ASSESSMENT REPORT

Student Accommodation Development 60-78 Regent Street Redfern SSD 6724 MOD 1

On 5 May 2016, the Applicant lodged an application (SSD 6724 MOD 1) seeking to reconfigure the ground floor, mezzanine and first floor levels as well as changes to the façade. The proposal also seeks approval to reduce the height of the building by 3.2 metres to be consistent with Condition B4 of the approval. The proposed modifications are outlined in **Table 1** below:

60-78 Regent St
Redfern
Ground Floor Plan

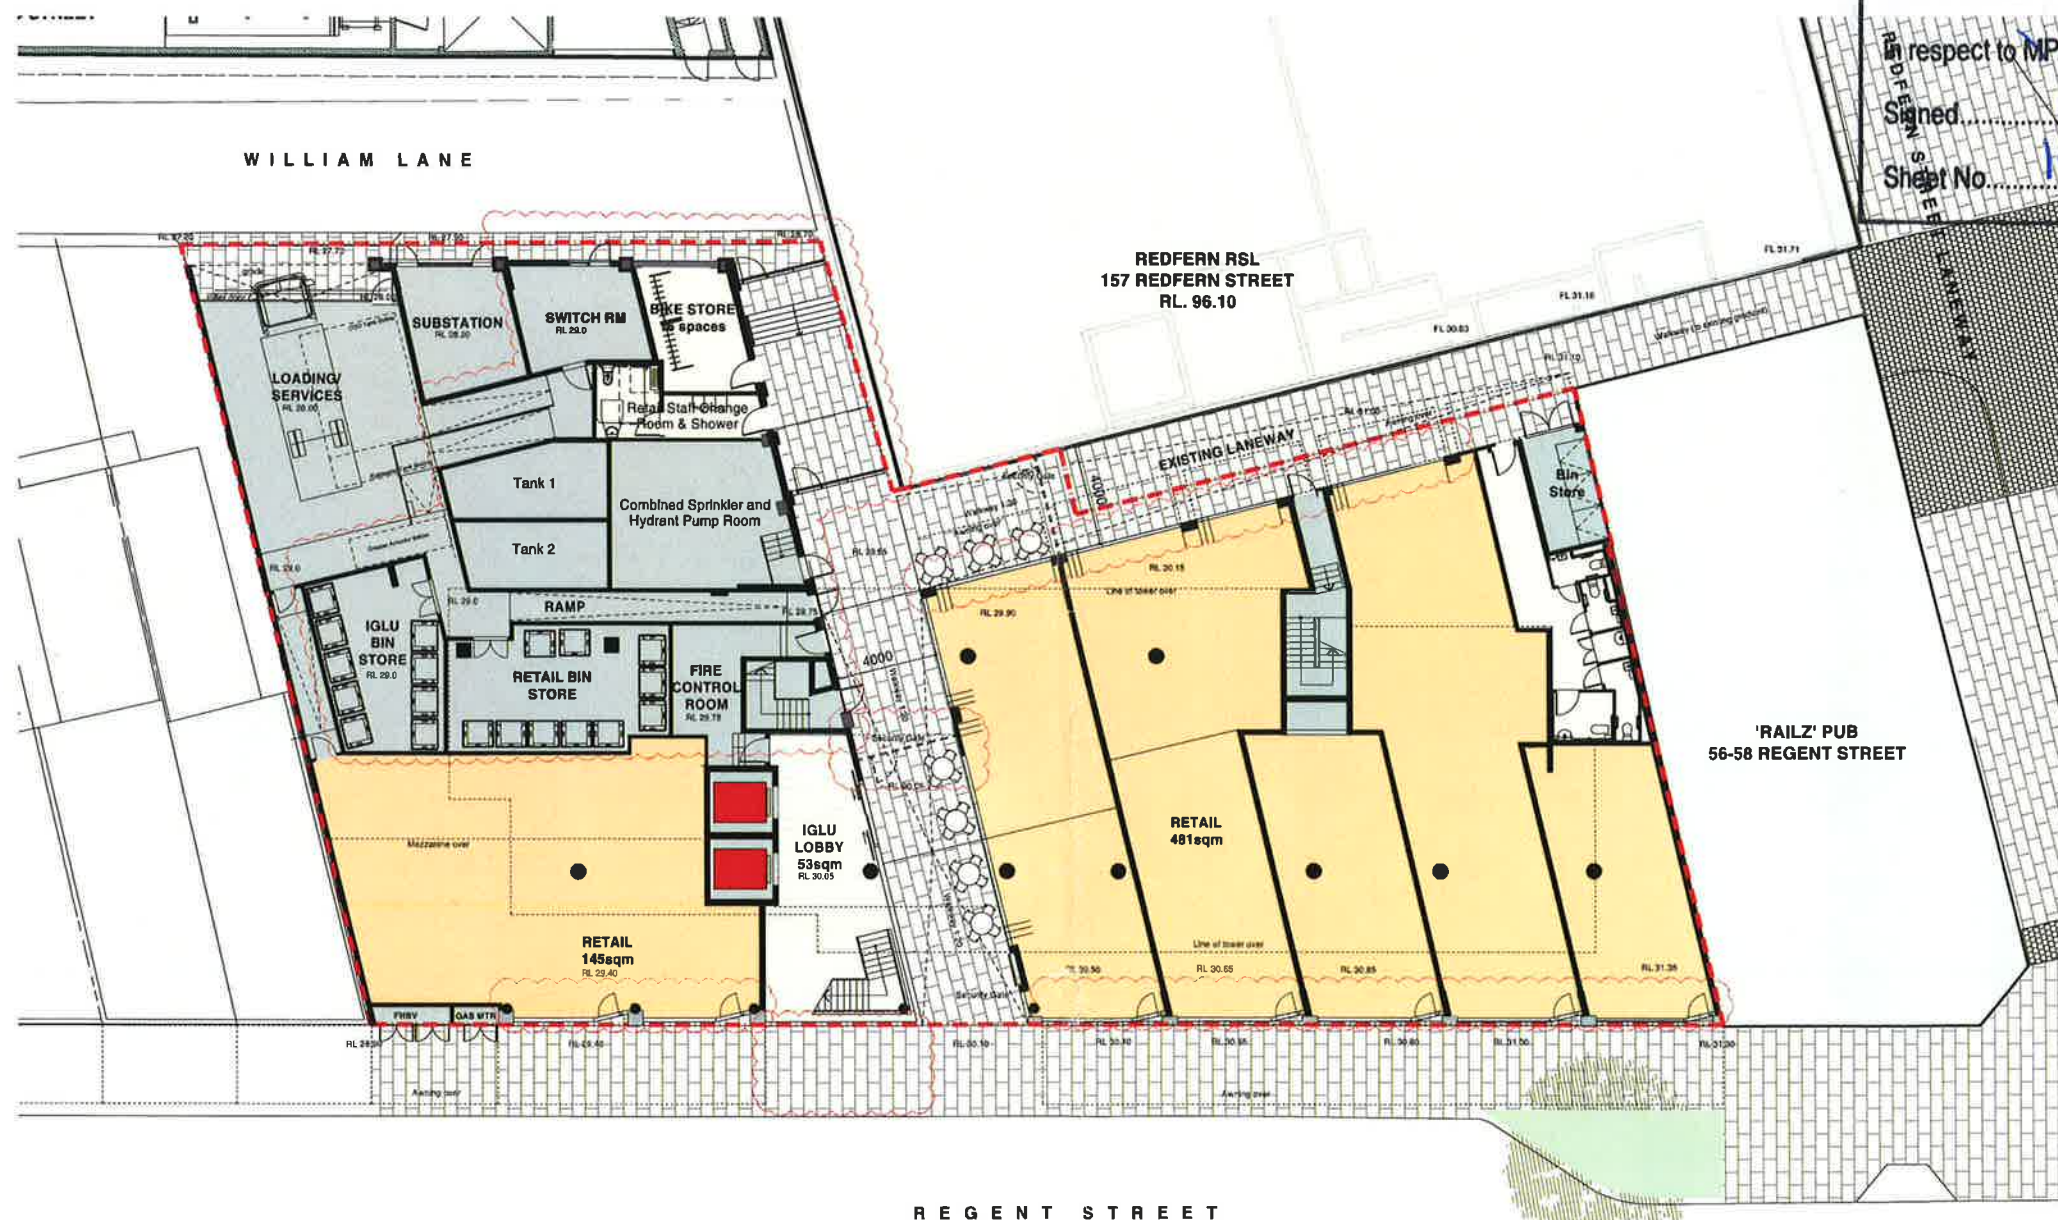
Proposed Modification	
<i>Ground Floor</i>	<ul style="list-style-type: none"> • Basement level plant to be deleted (except lift overrun) and plant/service areas relocated across the ground and mezzanine levels. • Ground level footprint reduced to provide open air connection to William Lane, with security gates installed to limit access to staff only. • Ground level back-of-house areas re-planned with the community room moved to Level 1. • Front ground level security gate (near Regent St) moved back into laneway and located under Level 1, enabling full height security. • Redesign of Regent Street shopfront doorways. • Changes to retail staff rooms and amenities.
<i>Mezzanine</i>	<ul style="list-style-type: none"> • Required fire egress stair added. • Required stair pressurisation fan room added.
<i>Level 1</i>	<ul style="list-style-type: none"> • Footprint expanded so that reception/office connects to rear façade and windows added to façade. • Community space/gym relocated from ground floor. • Minor replanning of internal rooms. • Required stair pressurisation fan room added to rear of northern stairwell.

<i>Public Domain and Security</i>	<ul style="list-style-type: none"> • The relocation of the Community Room from the rear ground floor level to the centre of Level 1, and the deletion of windows facing toward the rear laneway, would potentially reduce the activation and passive surveillance of William Lane. • However, the Department considers the proposal is acceptable as: <ul style="list-style-type: none"> ○ William Lane includes no active frontages and is not typically used by pedestrians. Rather, it is a service lane for vehicular access and servicing and there is no expectation that active frontages would be provided to the laneway; 	No additional conditions or amendments necessary.

Issue	Consideration	Recommendation
	<ul style="list-style-type: none"> o a reasonable level of passive surveillance of the laneway would still be achieved from the first floor student accommodation windows which overlook the laneway and the new open air access way to William Lane (which would permit some views through the proposed security gates); and o existing conditions of consent require provision of public domain lighting and CCTV surveillance in consultation with Redfern Police, providing additional security and surveillance of the laneway. • The Department is therefore satisfied that the proposal would provide a reasonable level of surveillance and security to the service laneway, despite the deletion of the Community Room windows. 	
<i>Privacy</i>	<ul style="list-style-type: none"> • The proposal incorporates three additional first floor windows in the rear elevation facing 157 Redfern Street. • The Department has assessed the potential privacy impacts on the adjoining building at 157 Redfern Street and notes that it presents a blank podium wall to the subject site at the height of the proposed windows. • The Department is therefore satisfied that no unreasonable privacy impacts would arise from the proposed additional first floor windows. 	No additional conditions or amendments necessary.

60-78 Regent St
Redfern
West Elevation

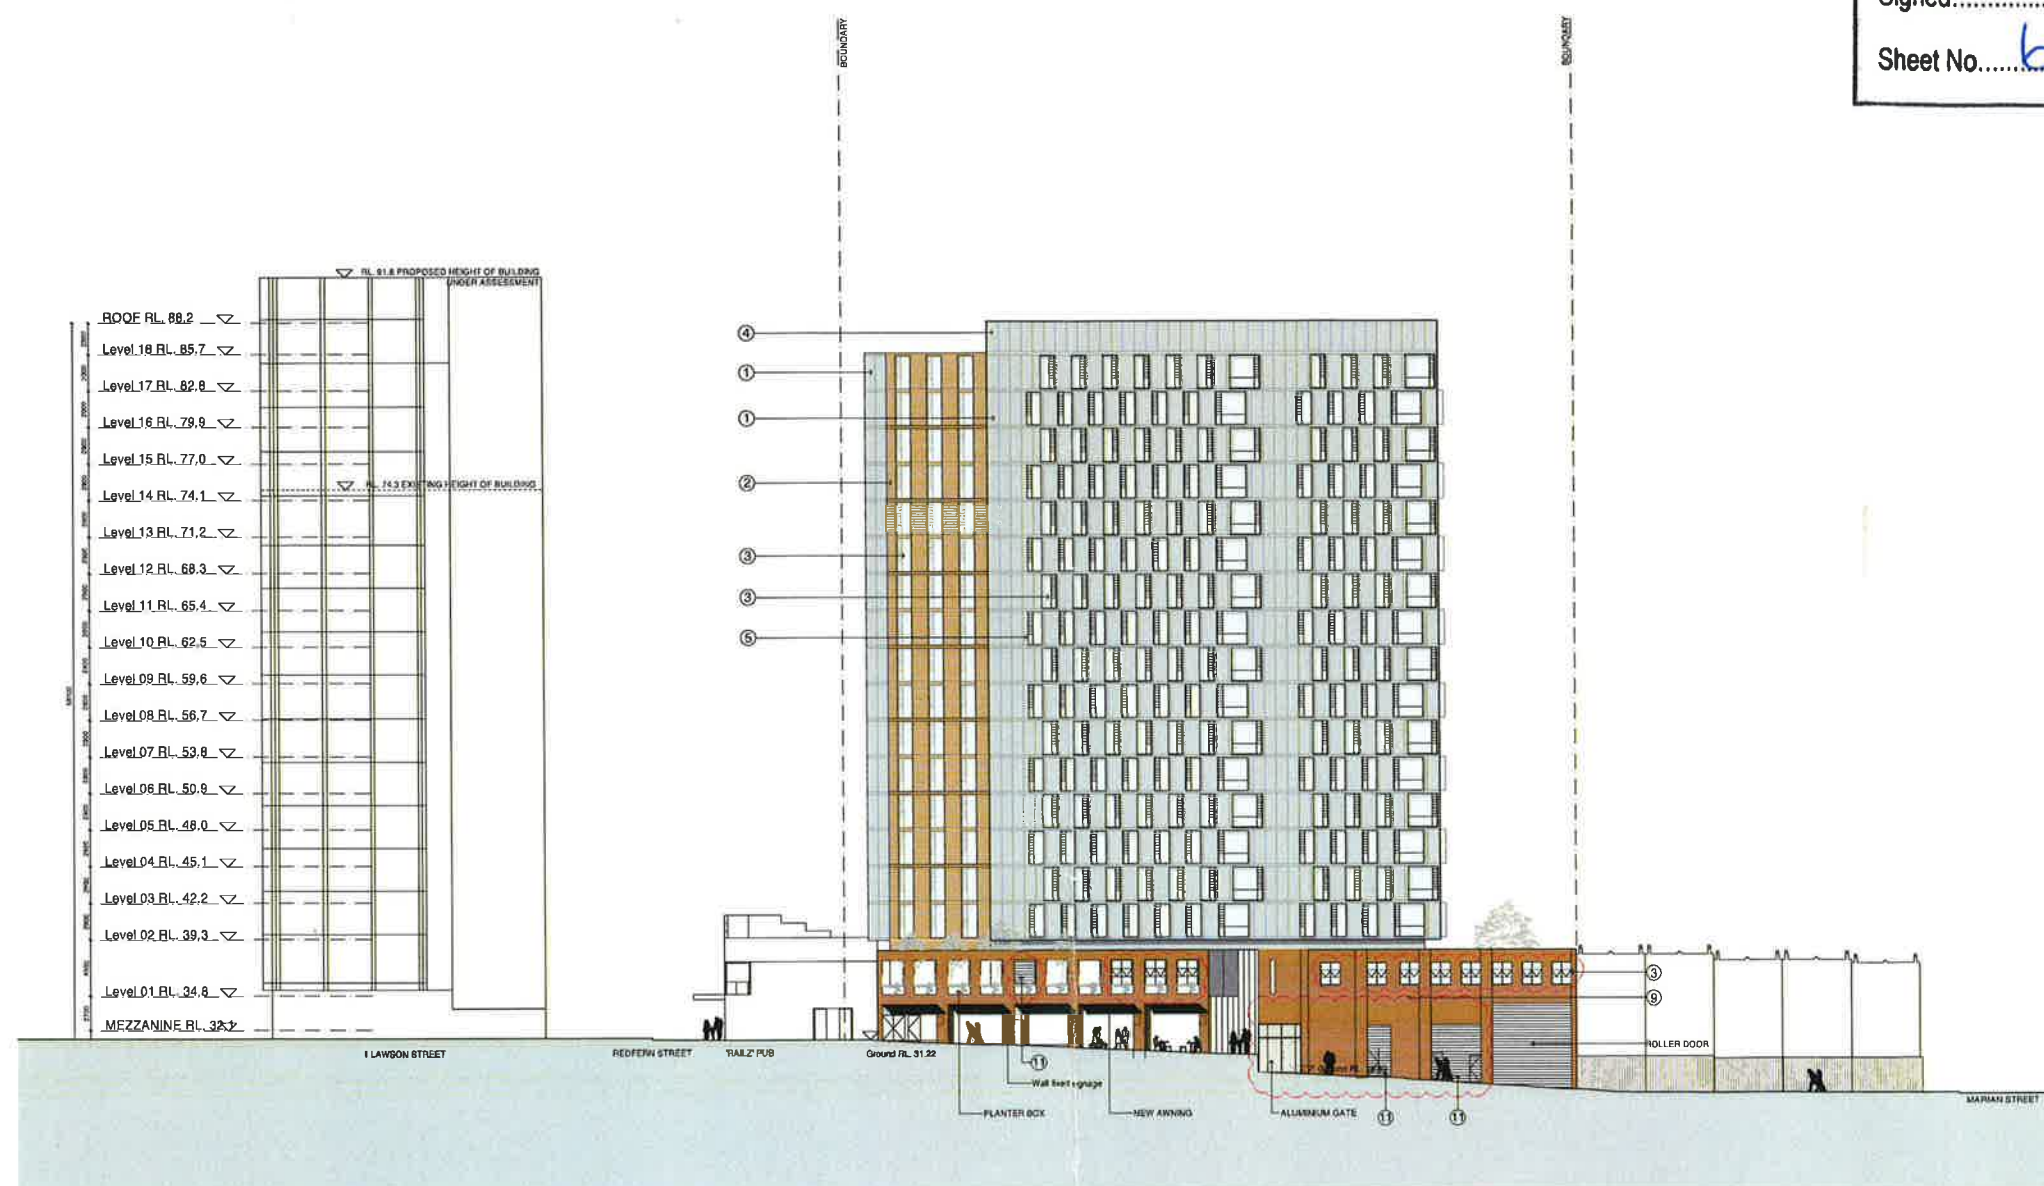
<i>Eastern elevation (Regent Street)</i>	<ul style="list-style-type: none"> • Shopfronts changed to single-door design. • Awning in front lobby deleted. • Lobby height reduced. • Cladding to plant / meter room is changed to aluminium louvers for ventilation.
<i>Western elevation (rear laneways)</i>	<ul style="list-style-type: none"> • William Laneway façade updated to include switch room louvered doors. Windows to former community room deleted. • Gate added instead of glazed doors. • Changed configurations of windows on Level 1 to become awning windows. • Windows/louvers added to reflect changes to Level 1 admin and Level 1 stair pressurisation fan room.
<i>Northern elevation</i>	<ul style="list-style-type: none"> • Material changes to the boundary wall (brick to precast concrete).
<i>Southern elevation</i>	<ul style="list-style-type: none"> • Material changes to the boundary wall (brick to precast concrete). • Louvres added to existing windows at Levels 3, 5, 7, 9, 11, 13, 15, 17.

60-78 Regent St
Redfern
Section CC

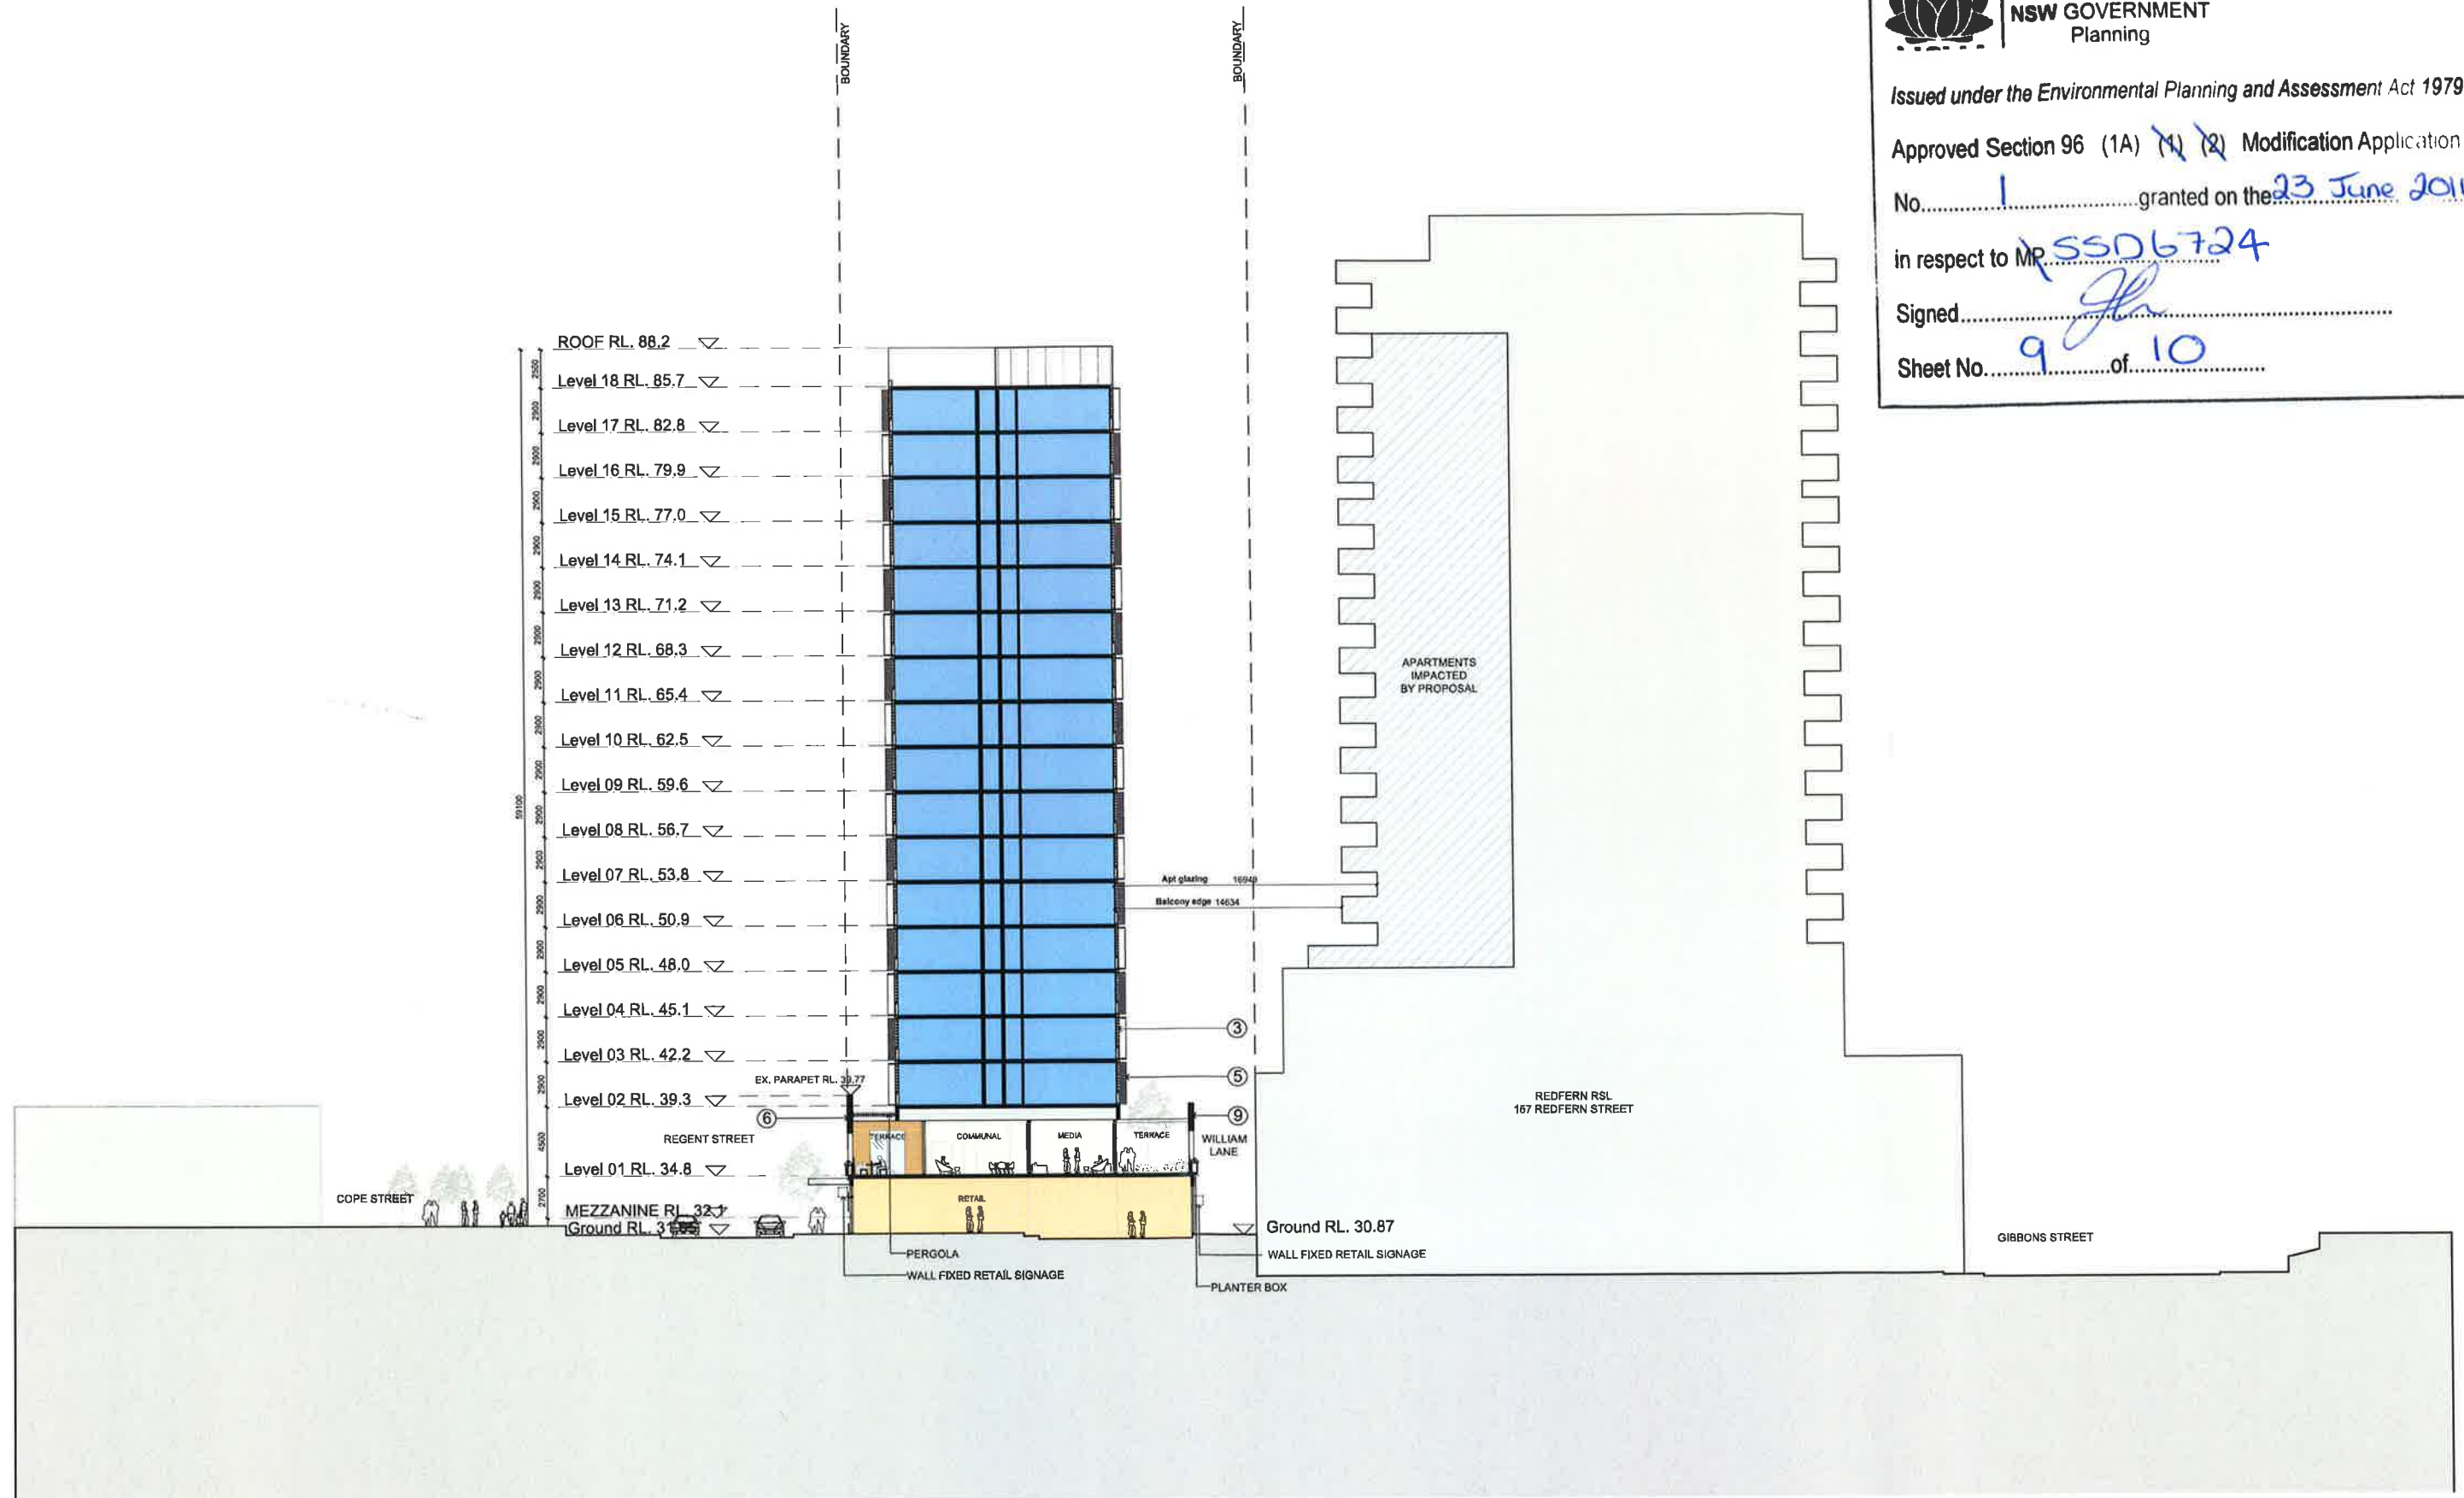
<i>Building Height</i>	<ul style="list-style-type: none"> • The Commission imposed Condition B4 which requires the overall height of the building to be reduced by 3.2 metres to a total height of 88.2 metres AHD. The height reduction would be achieved by reducing the floor to floor height to 2.9 metres while still retaining the minimum floor to ceiling height of 2.7 metres. • The plans submitted with the modification demonstrate that the total building height has been reduced to 88.2 metres AHD in compliance with the requirements of Condition B4. Accordingly, the Department recommends the condition can now be deleted. 	Condition B4 is recommended to be deleted
<i>Contributions</i>	<ul style="list-style-type: none"> • The development is subject to the Redfern-Waterloo Contributions Plan 2006 which requires payment of a Section 94A development levy of 2% of the proposed cost of carrying out the development. The Applicant has confirmed that the capital investment value would not change as a result of the proposed modification. Therefore no additional Section 94A contributions are required. • The development is also subject to the Redfern-Waterloo Authority Affordable Housing Contributions Plan 2006 which requires a contribution based on the total additional floor space developed on the site. The Department notes that there is a minor reduction of 120 sq.m of floor space. However, the existing condition requires confirmation of the final floor space prior to payment of the contribution as well as flexibility to allow for an alternate arrangement for the provision of affordable housing. As such, the Department is satisfied no amendments to the condition are necessary. 	No additional conditions or amendments necessary.
